Your Ref: OWPC25945
Our Ref: PO/1/20/HH 21-01-2020
Please ask for:
Zac Denton

Retention of car port to side elevation & raised roof to existing garage.
9 Arundel Road Poling

Drawing Number	2020/05	Sheet	1 of 1
----------------	---------	-------	--------

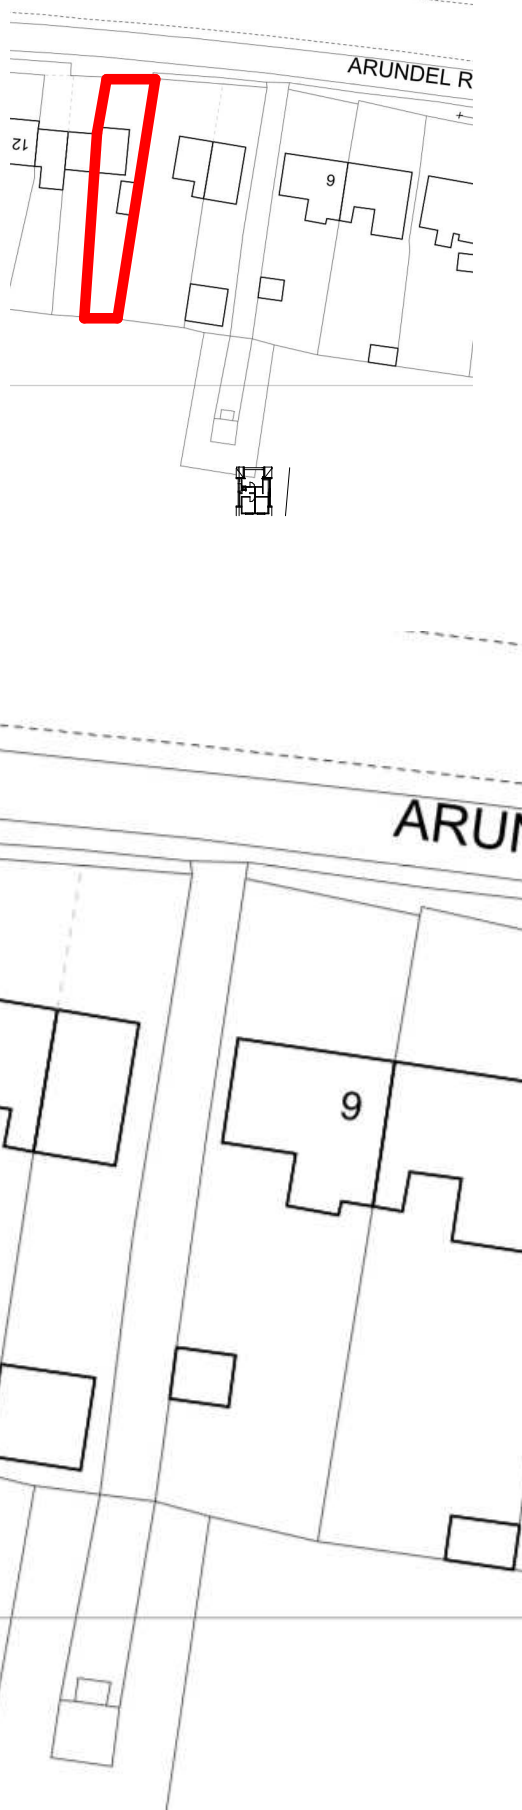
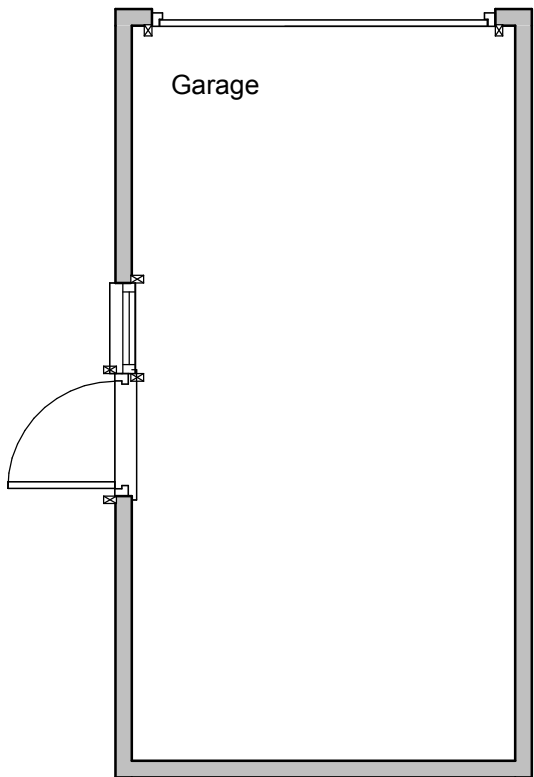
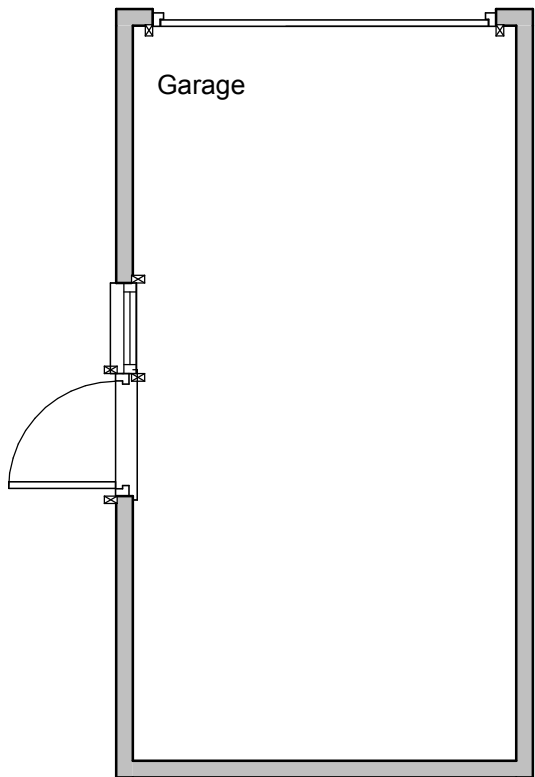
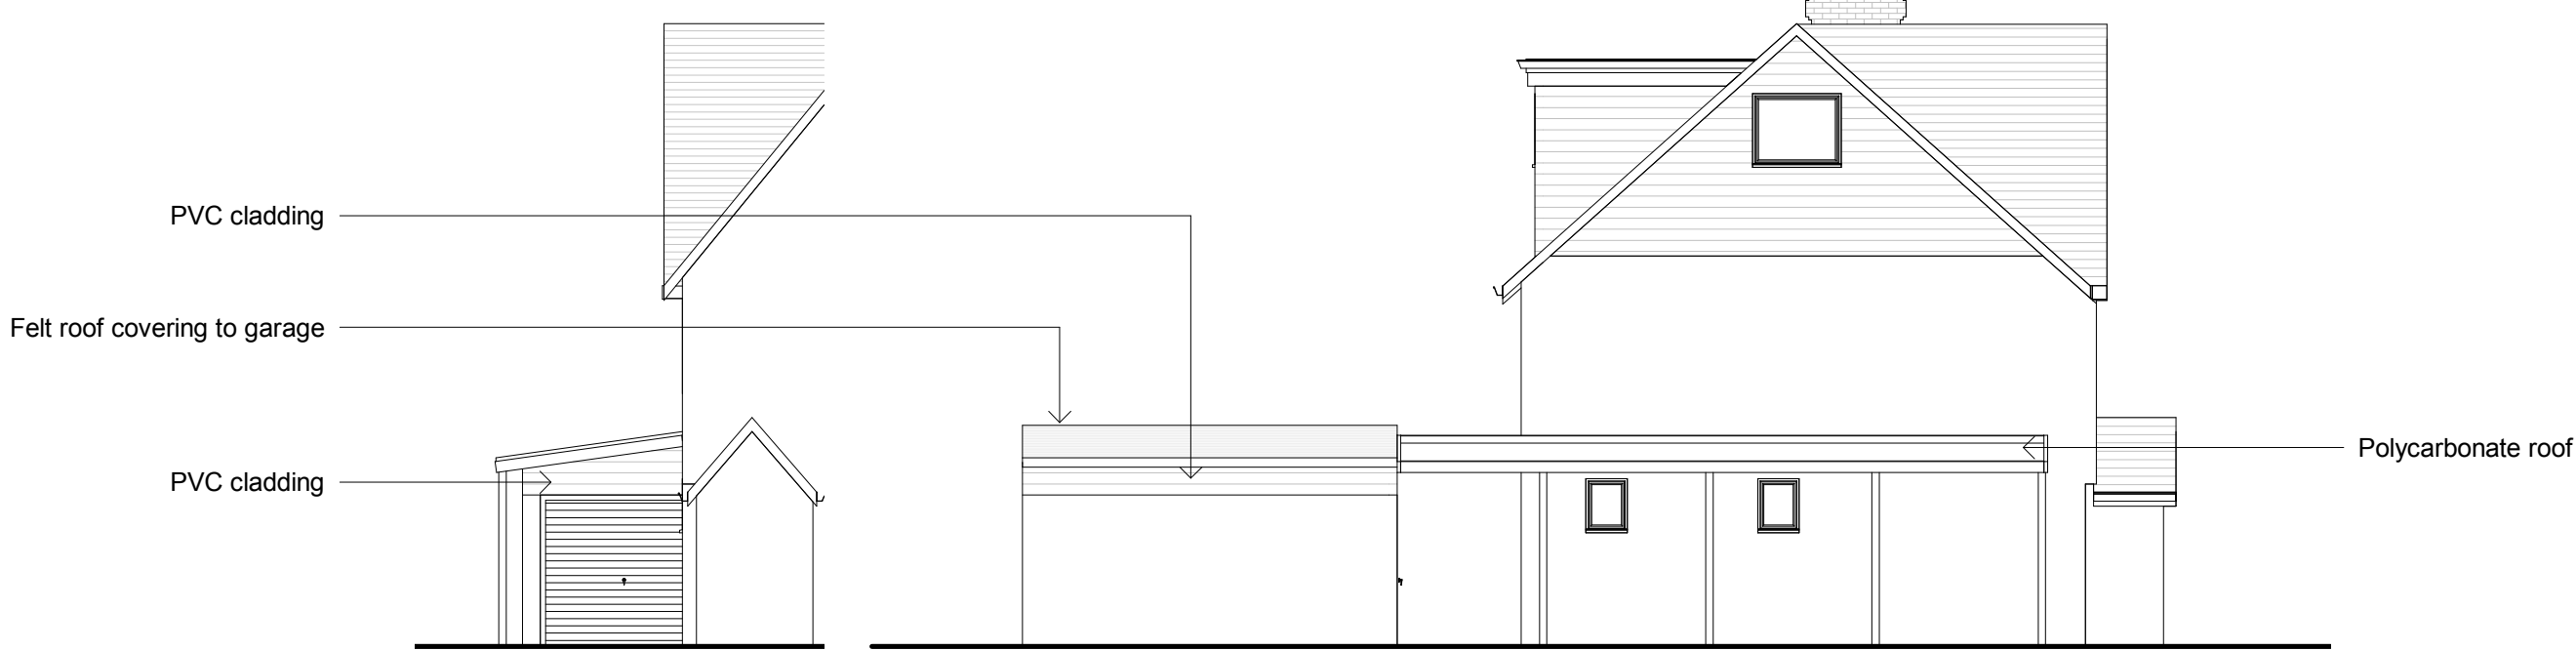
this is apropos to the building application, not realising that the garage roof extension was built with out permission i feel that it should be said that this is an ugly edifice that dominates both the view from our house and from our garden as it rises prominently above the 6ft fence eye line, i hope that this in conjunction with the further planned carport construction over the easement between our properties will be give correct consideration.
